**PREPARED BY:
TERRA NOVA ENGINEERING, INC.**

PLATTE SELF STORAGE

SITE DEVELOPMENT PLAN

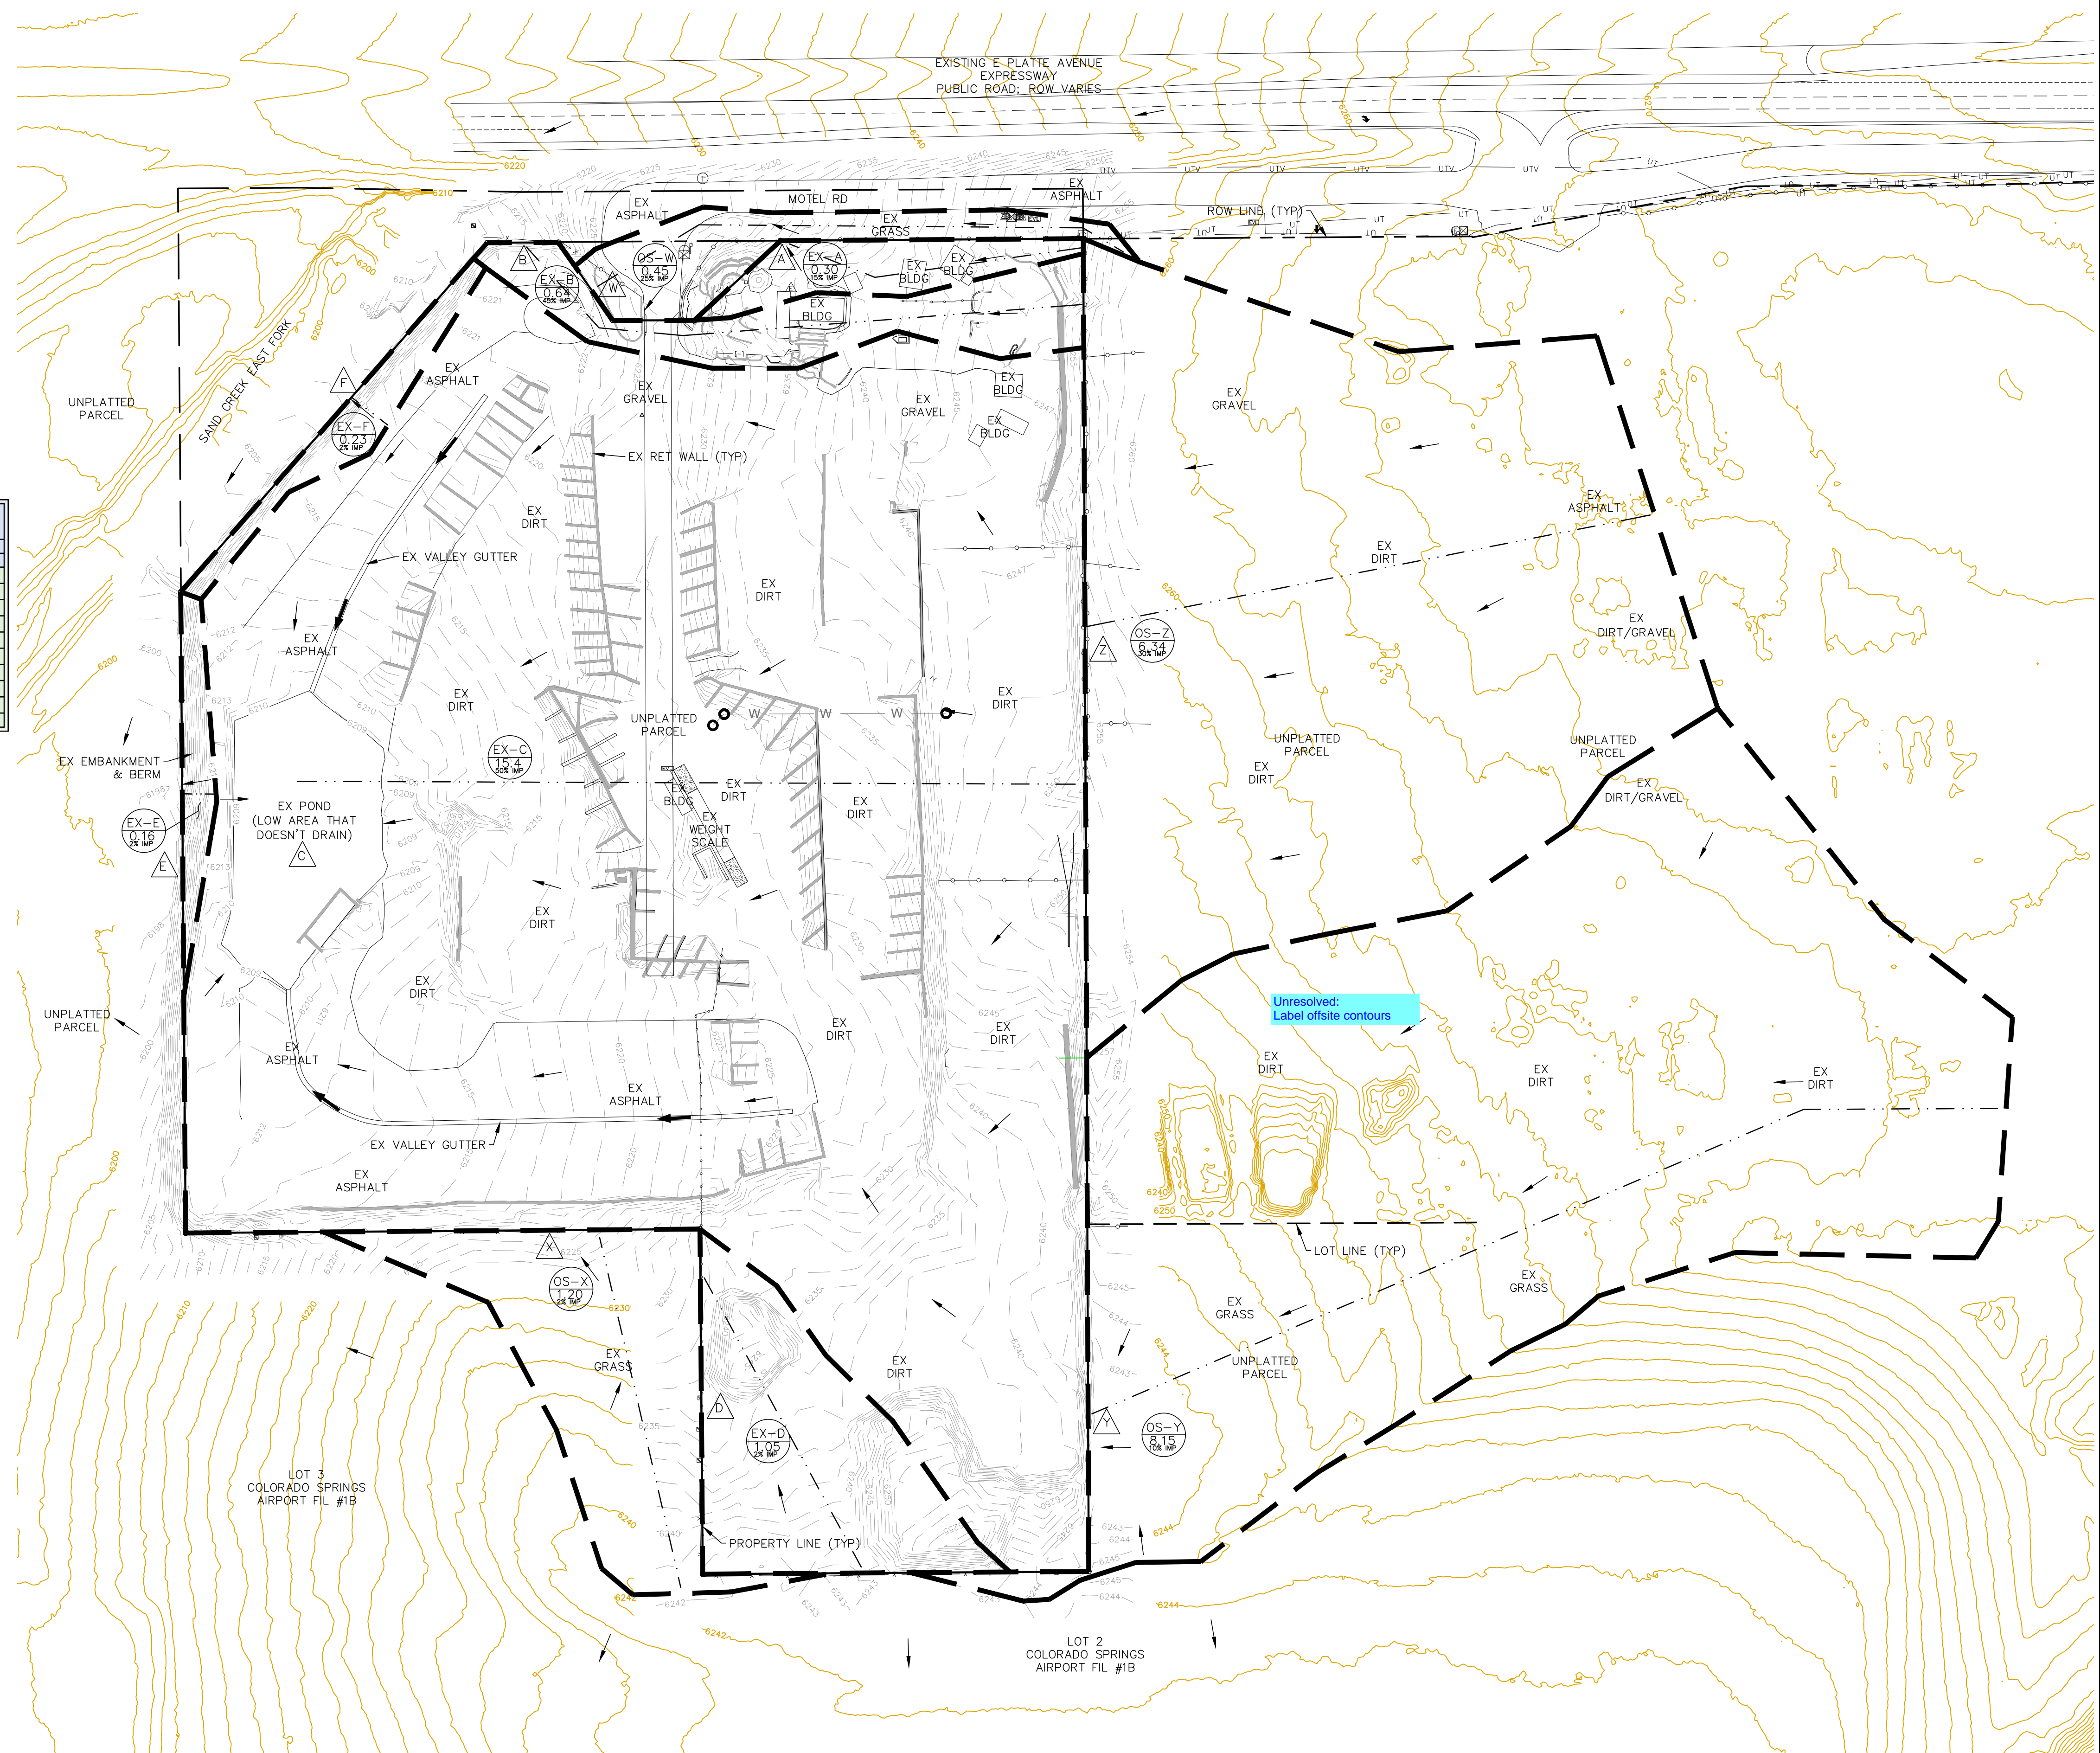
Show and List Base Flood Elevations in Floodplain
